**Land To The South And Adj To South Side
Steeple Aston**

22/01788/F

Proposal: Variation of condition 2 (plans) of 21/02318/F - proposed amendments to plot 10

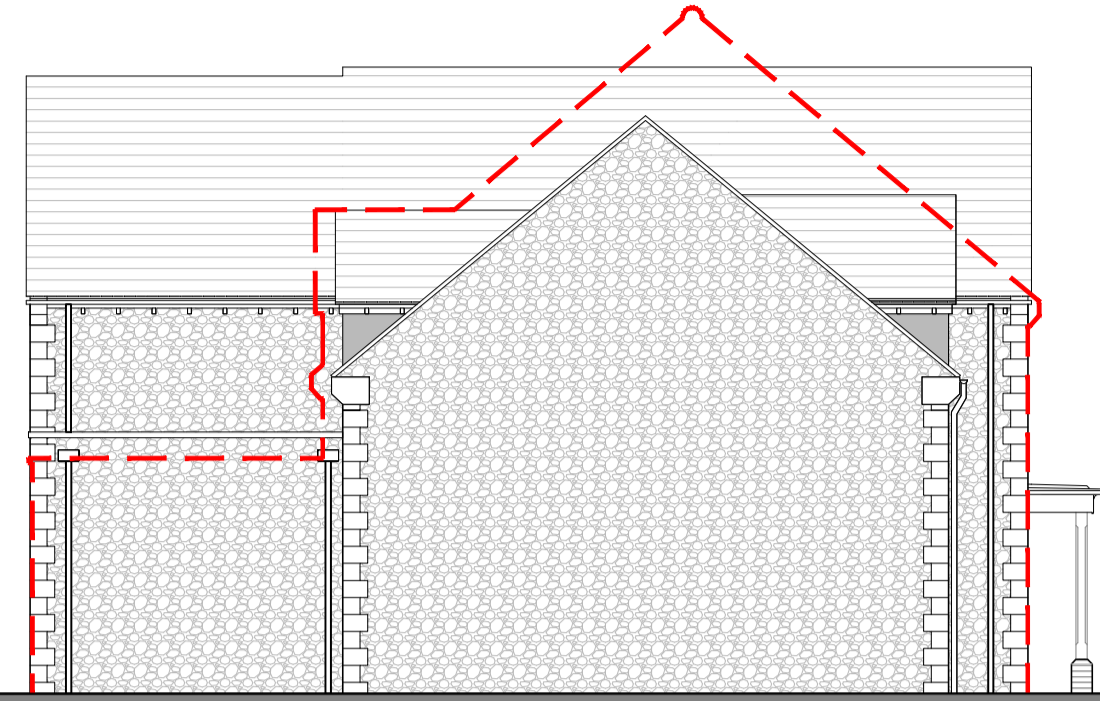
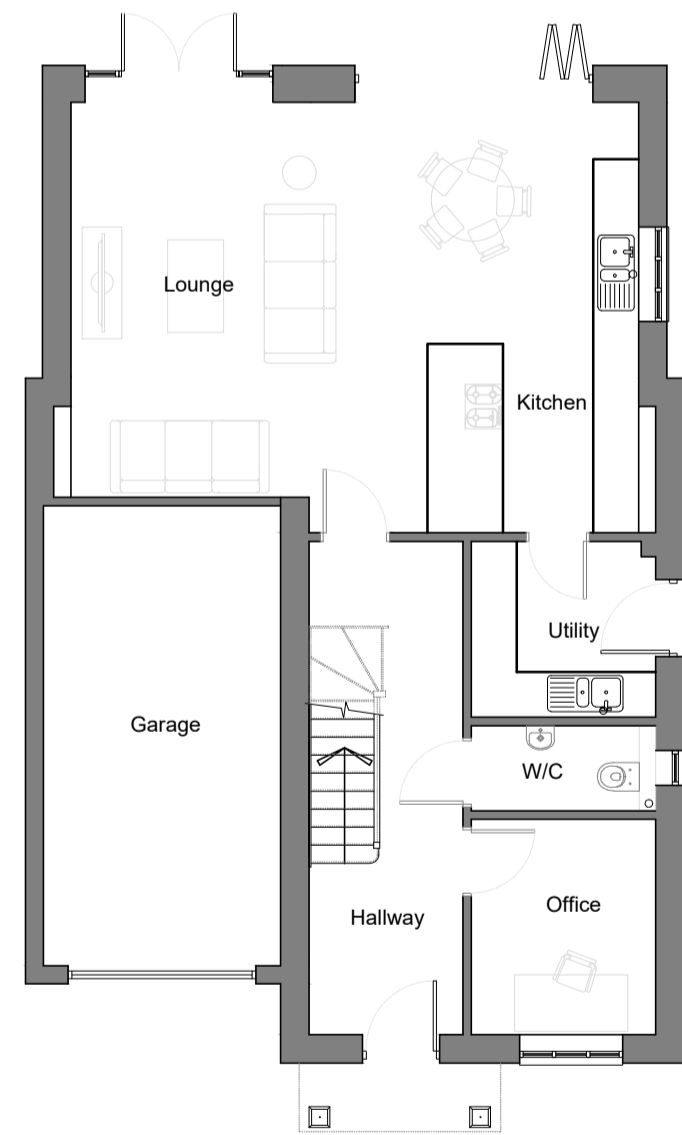
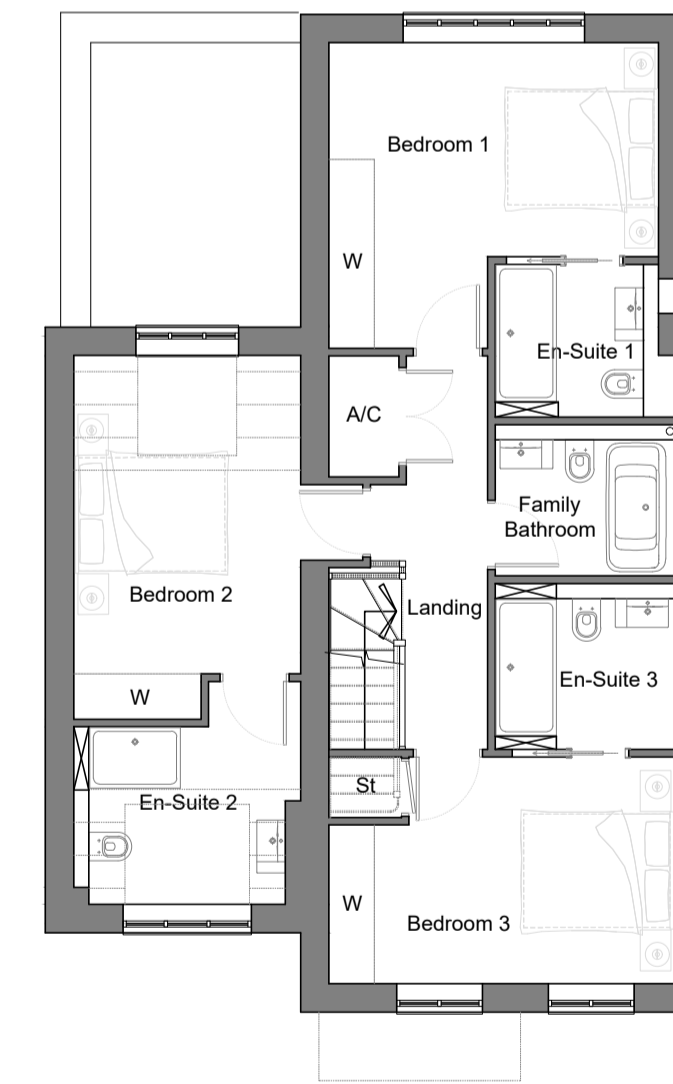
- 2.1. Planning permission is sought for the variation of Condition No: 2 (plans) of 21/02318/F to amend the design of Plot 10. The amendments include the reduction in the overall height of the dwelling and the reorientation of the main roof pitch. Additional floorspace at first floor is also to be created with the addition of a first floor extension over an approved flat roofed single storey element.
- 2.2. Amended plans have been received further altering the design of the dwelling setting the rear two storey element in from the western boundary slightly to break up the length of the western elevation.

- 8.3. Plot 10 lies to the westernmost part of the site adjacent to a car workshop. With the submission of the amended plans the proposed amendments to the design of the dwelling are considered to be acceptable and similar to the design of other plots in the development. The reduced scale of the dwelling relative to the original approval helps to soften the appearance and setting of the development when approaching the village from the west. Although it results in a gable frontage to the highway it would be set back significantly from the highway and the overall effect of the reduced height and omission of a deep gable end to the side is a positive change which is to be welcomed, especially now the rear element of the dwelling has been set in from the side elevation.
